Replacement summer house. This application may affect the setting of a listed building and affects the character and appearance of the Arundel Conservation Area.

13 Mount Pleasant Arundel

Thank you for your internet representation made on 15th November 2019 which has been recorded as '**no objection**' with the comments as follows:

SUN LOUNGE DIMENSIONS
ALL DIMENSIONS APPROXIMATE

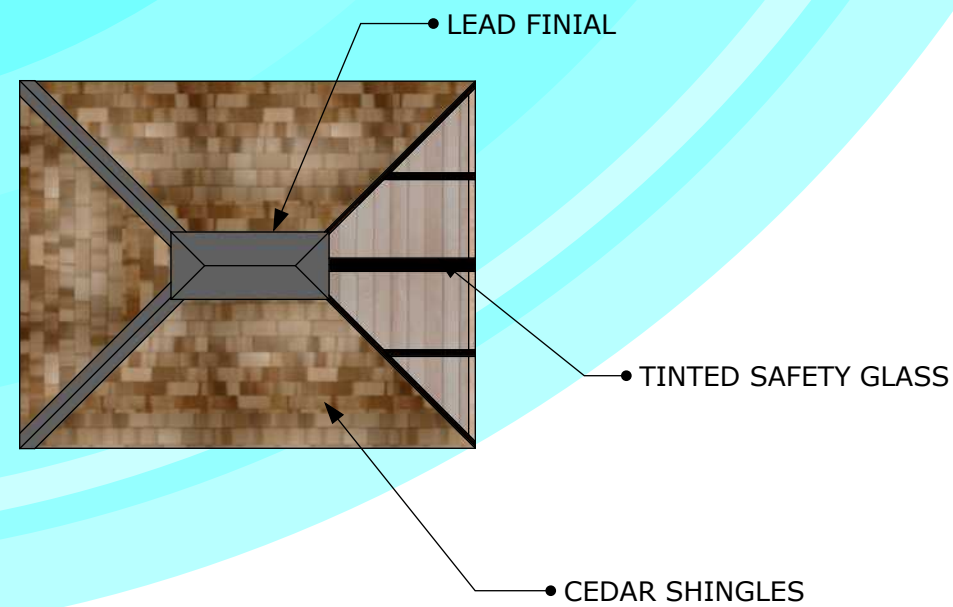
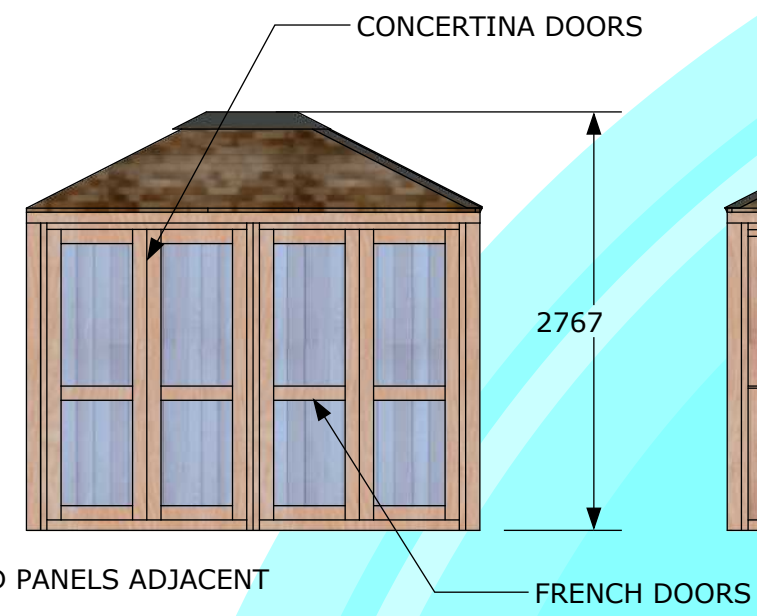
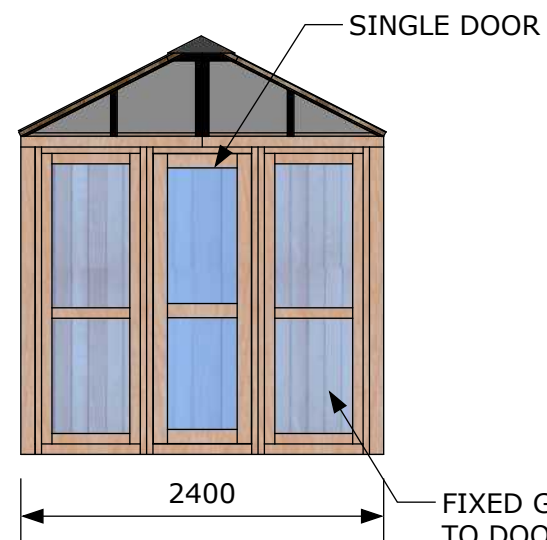
It is considered, though, that the use of cast iron or aluminium rainwater goods would be more appropriate than pvcu in an historic area.
